31/10/2019

**Australian Technology Park Building 2 Modifications (SSD-7317-Mod-17)  
Request for Additional Information**

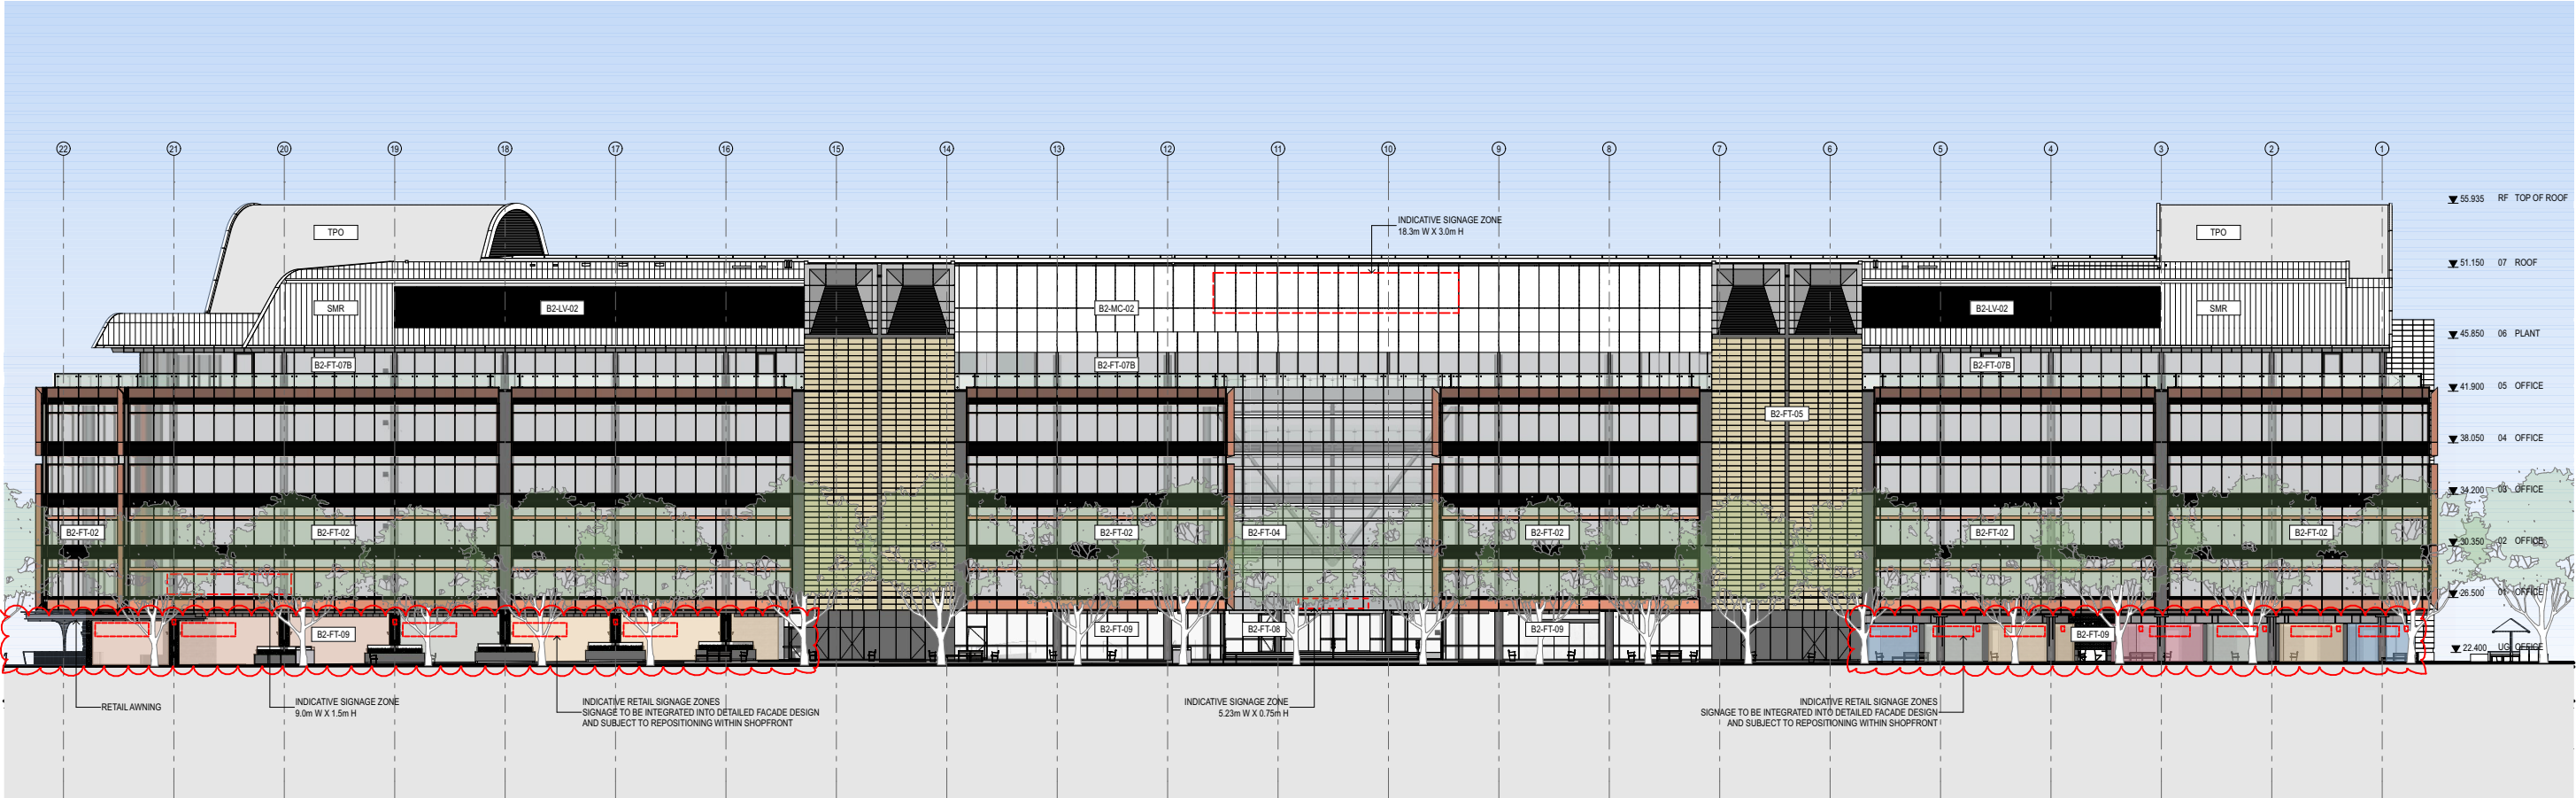
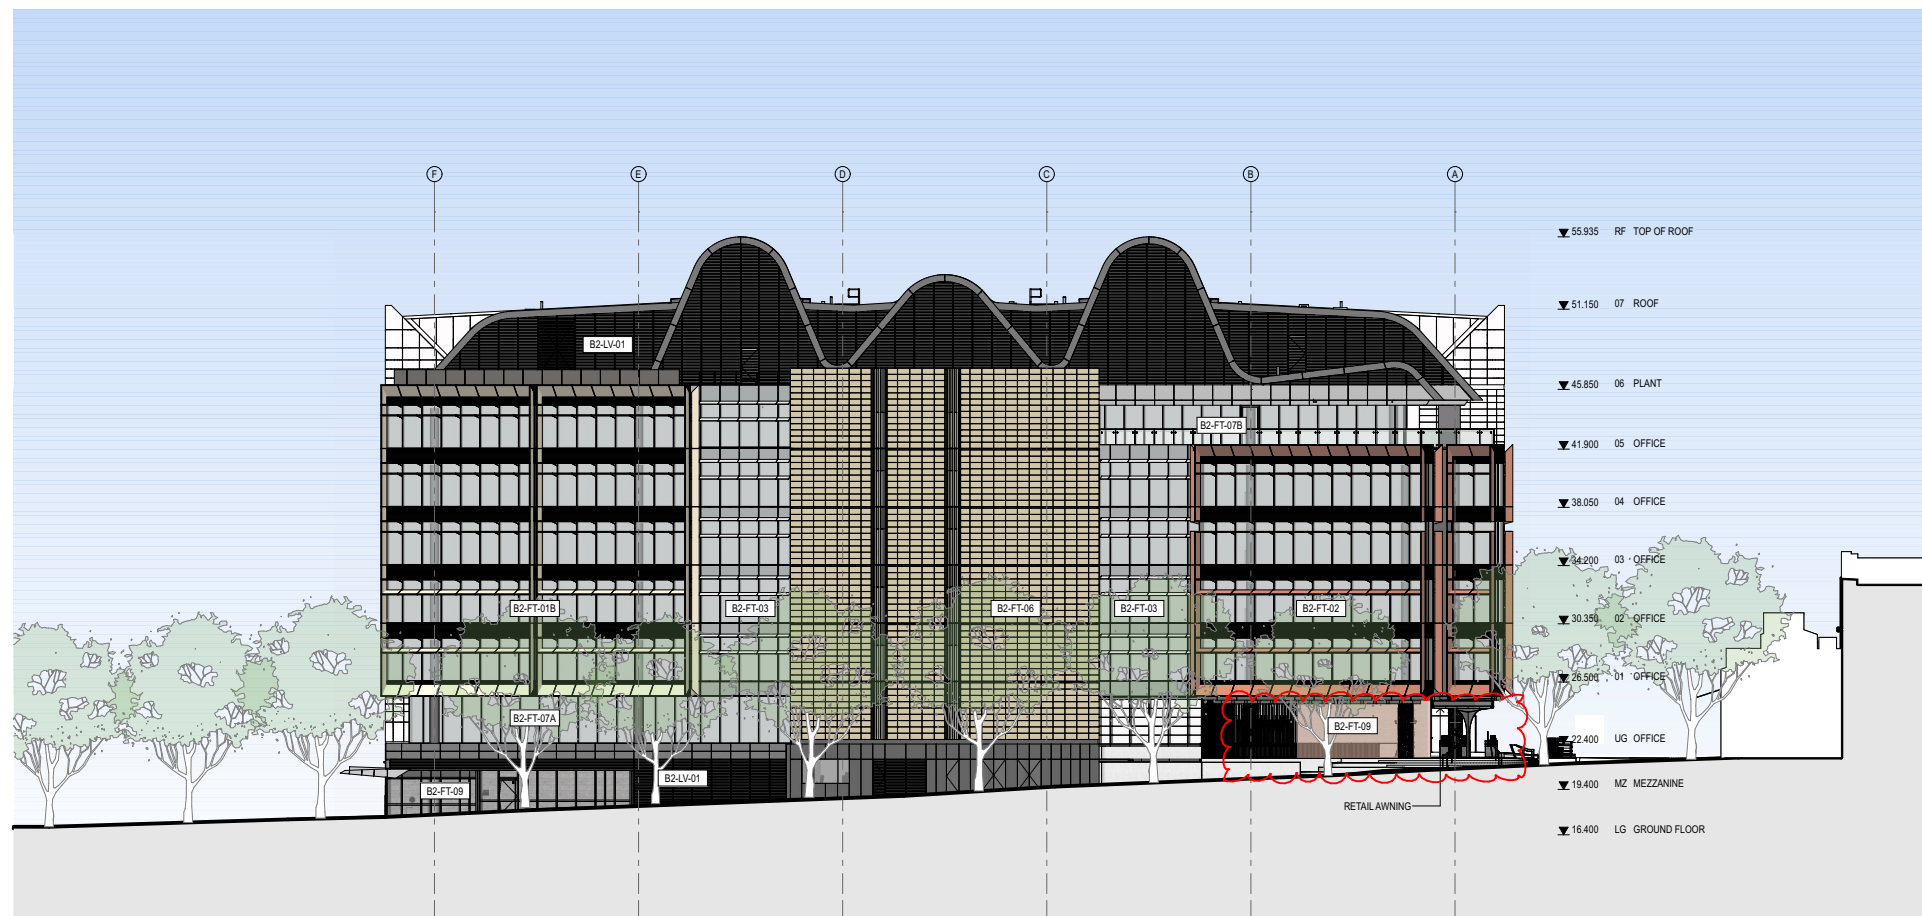
- confirmation that all landowner's consents have been provided
- further details responding to Council's concerns regarding the level of detail within the Retail Design Guide on acceptable shopfront designs
- clarification on the number of signage zones proposed for Building 2, noting that the modification report states a maximum of 23 signage zones are proposed but not shown on the plans
- clarification on the intended function of the proposed rooms near the eastern end of both the western and eastern retail zones.
